DECISION DELEGATED TO DEVELOPMENT MANAGER

Application No:	H16-0790-21	Applicant:	Merkur Slots (UK) Ltd.
Proposal:	Proposed Signage		
Location:	32-33 Hall Place Spalding		
Terminal Date:	16th September 2021

PROPOSED SHOPFRONT ELEVATION

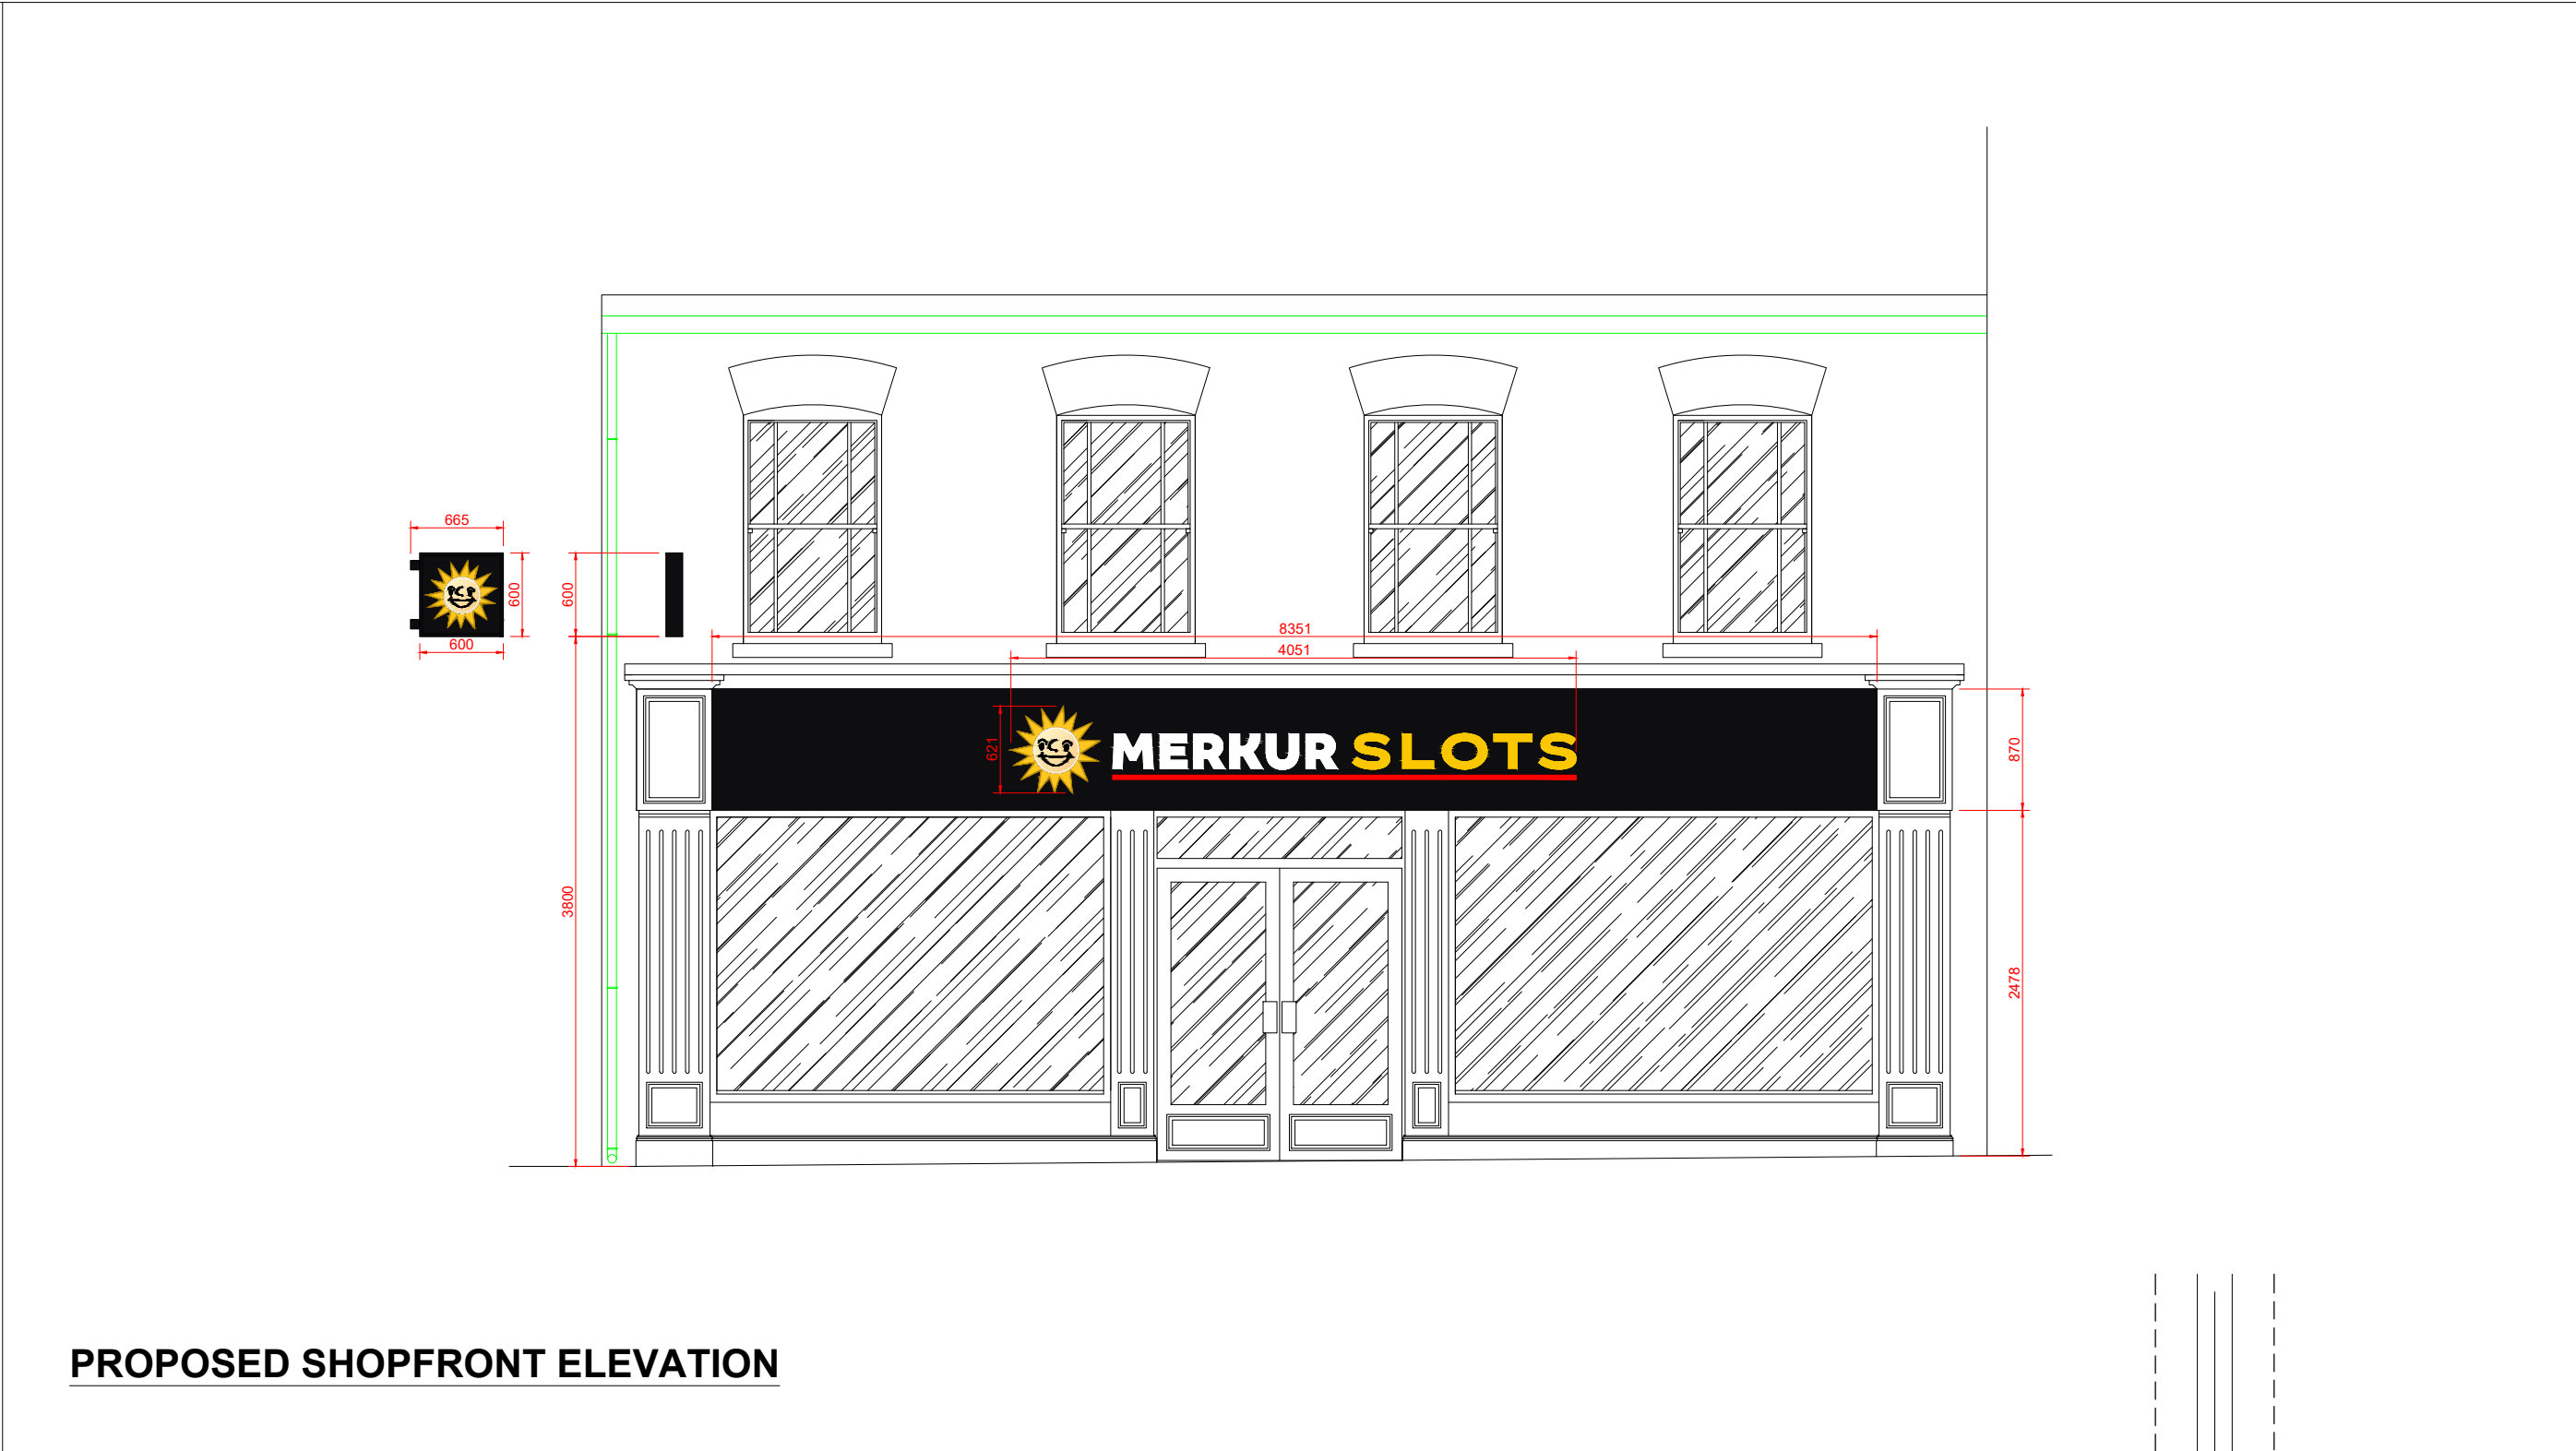
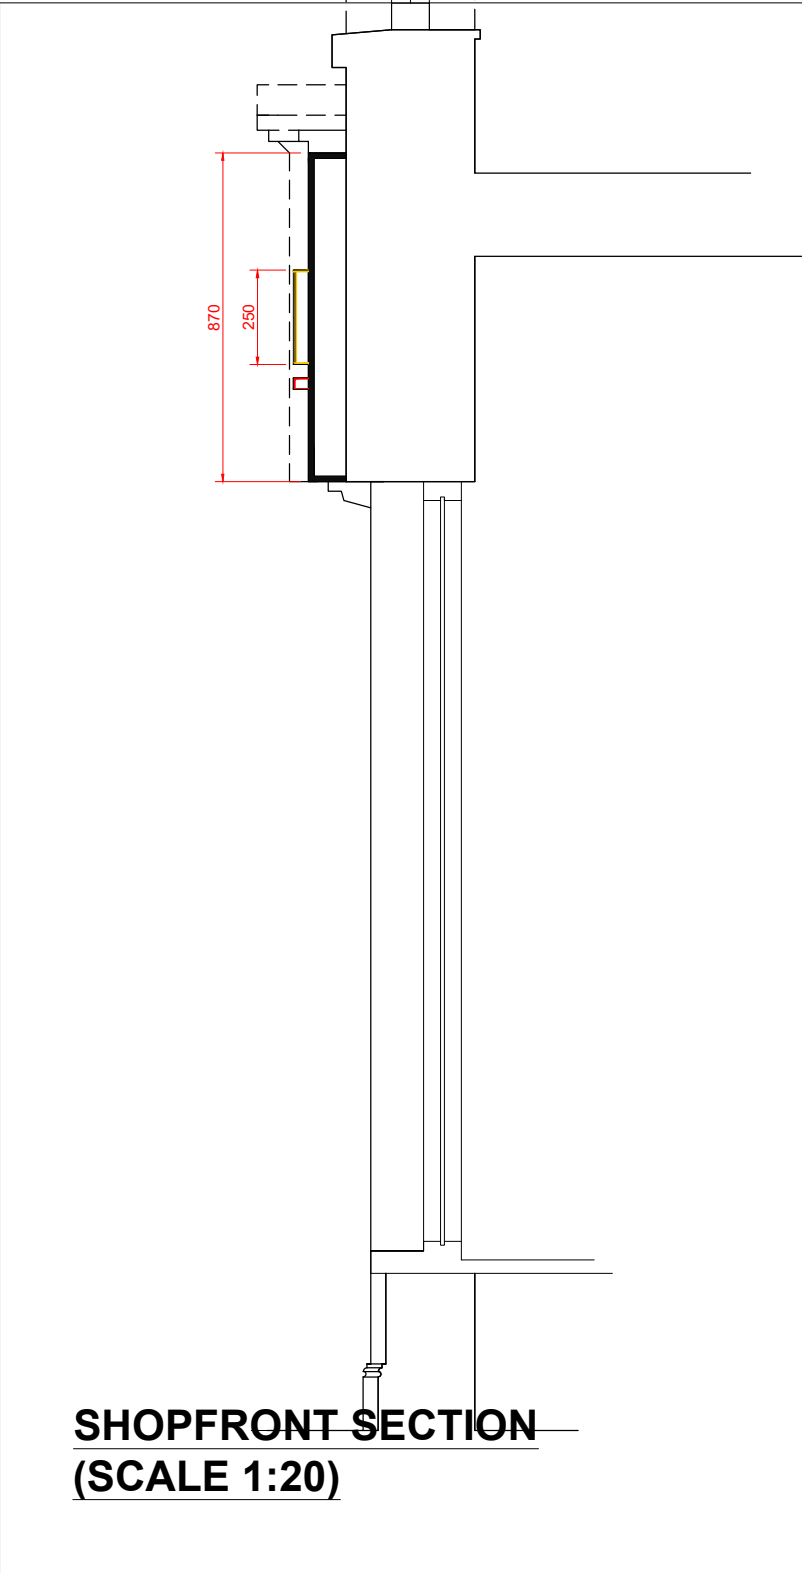
From a Conservation perspective, do not feel that the proposed signage is appropriate in design and construction for the Conservation Area setting, especially in such a prominent portion of the primary shopping area of Spalding.

The proposed restoration of the pilaster details and the avoidance of direct application vinyl is appreciated. However, believe that cumulatively, the modern, somewhat characterless design of the signage and the bold, bright colour scheme (notwithstanding the black background) are at odds with the aims of Policy 29 of the South East Lincolnshire Local Plan, in that they do nothing to assist in the enhancement of the character and distinctiveness of the Spalding townscape. A more carefully considered, heritage focussed proposal, that was commensurate with the Conservation Area would be far more preferable.

Additionally, note that it is proposed that the signage would be internally illuminated, which is again, at odds with the standard of the conservation area. Apart from in exceptional circumstances, internally illuminated signage is not generally considered to be appropriate for signage in a conservation area owing to the fact that it completely alters and modernises the character of a townscape, especially at night. As such, would suggest that any successful proposal should only include external illumination methods.

The impact of the proposals upon the Spalding Conservation Area (SCA) is deemed to be unacceptable. This is due to the scale, colour and design of the proposed signage that would not be in keeping or sympathetic to the SCA. The proposal for a set of starkly coloured, large (relative to other, nearby signage styles), branded signs that would dominate the important Hall Place area of the Spalding Town Centre and SCA within which the proposed signage would sit.

In addition, the hanging sign is proposed to be installed above, rather than alongside the fascia, which would result in a high level, internally illuminated sign, out of character with this part of the conservation area. Looking at the signage as a package of works, the signage would impact heavily

upon various views of and from important elements of the SCA such longer views of the site from the surrounding shopping area and of Hall Place itself, which is a characterful element of the SCA in its own right. It is not considered that the signage would preserve or enhance the character or appearance of this part of the conservation area.
